TO: DIRECTOR INFRASTRUCTURE PROJECTS.

Submission Form

Epping to Thornleigh Third Track Proposal. Application number SSI 5132.

Figure S.6 Cross-section and elevation - New Cheltenham Station concourse building (see also S.5 for artist's impression)

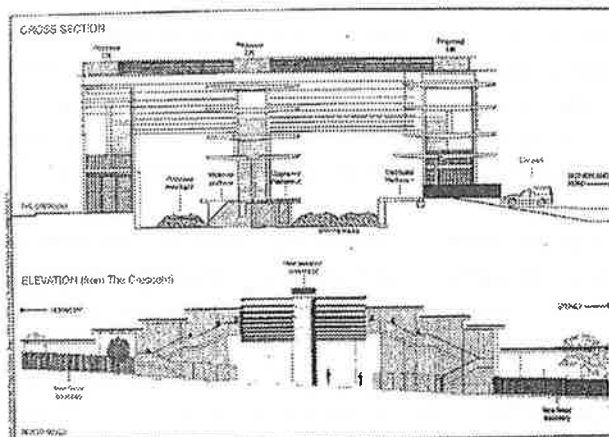
- The proposed redevelopment of Cheltenham Station shows no regard for the HCA. The visual impact of the proposed 13m high glass and steel concourse is totally unacceptable in this HCA.
